December 1, 2023

The following comments are the Environmental Public Health comments on the RU-23-00001 Teanaway Ridge Notice of Application. There is an existing, approved water system on the property that has been maintained and is in compliance and remains in the active status with the Washington State Department of Health, as a Group A-transient, non-community water system (WAC 246-290).

**Project RV Resort**  
 A Recreational Vehicle Resort on the Yakima River  
 Kittitas County, Washington  
 JANUARY 202011

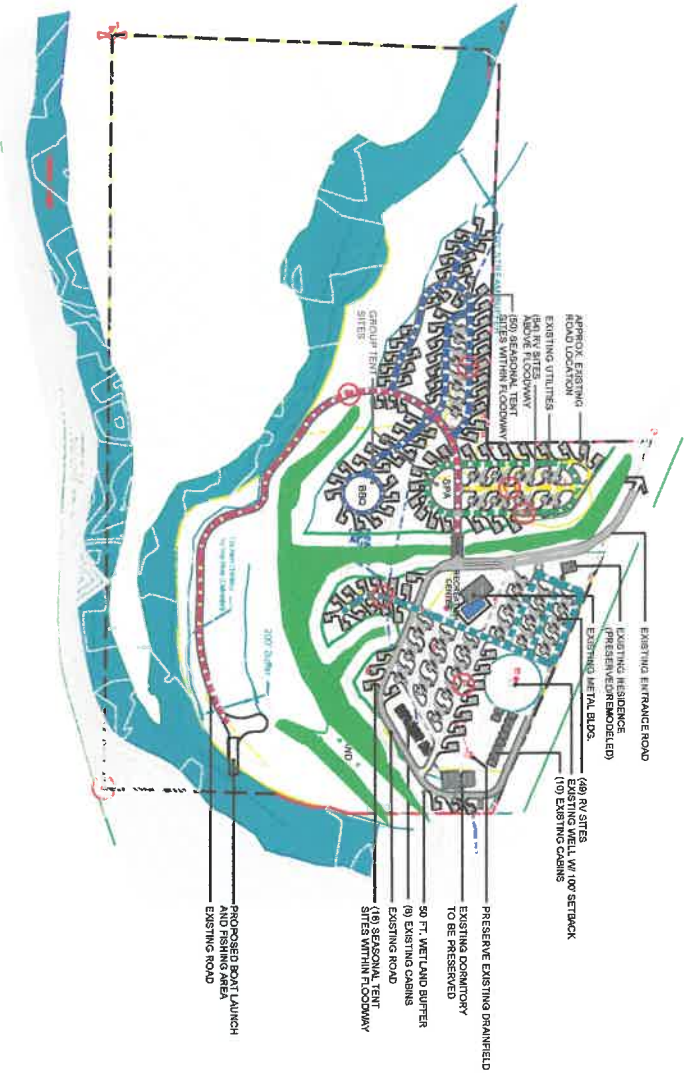
The applicant must evaluate the existing drainfields on the parcels as well as reach out to a licensed on-site septic system designer to ensure the future uses of the project will be adequately served by on-site septic systems. Additional site evaluations may be required. The parcels where the project is to be located have significant areas of floodway that need to be considered in the placement of future septic systems as they are not permitted in the floodway.
